**Section 96A of the Town & Country Planning Act 1990 (as amended)
Town and Country Planning (Development Management Procedure) (England) Order 2015 (as amended) - Article 10**

Non-material amenment following the grant of reference WA/18/19/PL for enlargement of front door canopy; external expression of chimney; variation of size & configuration of windows; omission of cladding to external elevations; variation of locations of brick & render to external elevations and brick plinth extended to whole of base.

Land adjacent to 1 Orchard Way Fontwell BN18 0SH

PROPOSED elevations:
comparative annotations with approved elevations

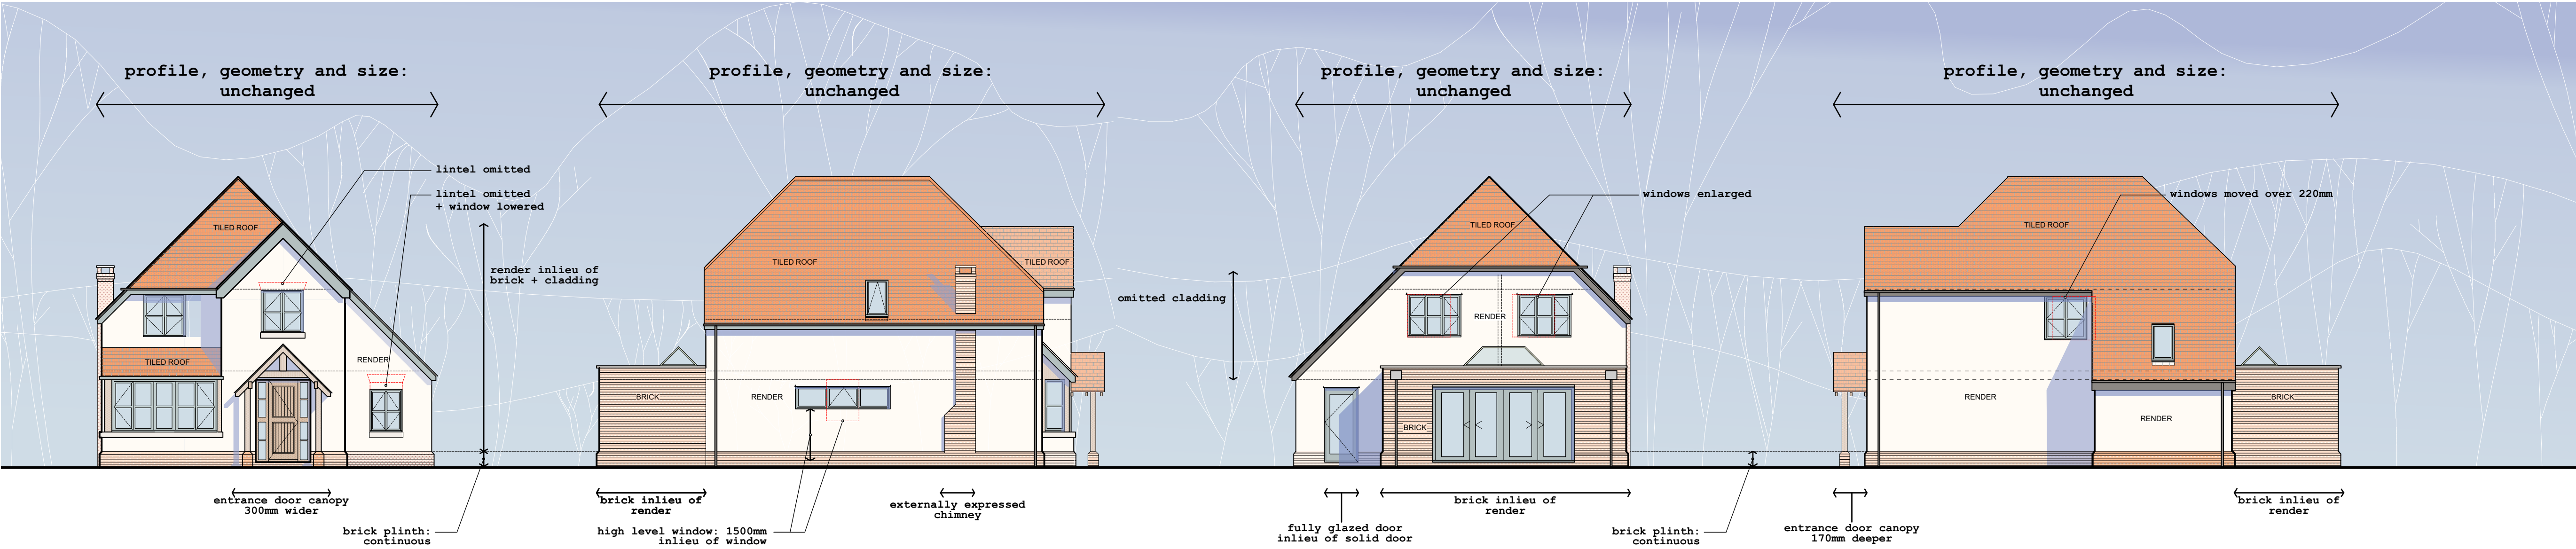
From the information submitted I am able to take the alterations namely enlargement of the front door canopy, external expression of the chimney, variation of the size and configurations of the windows, omission of cladding to the external elevations, variation of locations of brick and render to external elevations and brick plinth to be extended to whole of base of proposed dwellings as a Non Material Amendment to WA/18/19/PL. Drawing numbers nb:17101+101 rev I and nb:17101+11 Elevation and Floor Plans have therefore become the approved elevation and floor plans for planning permission WA/18/19/PL.
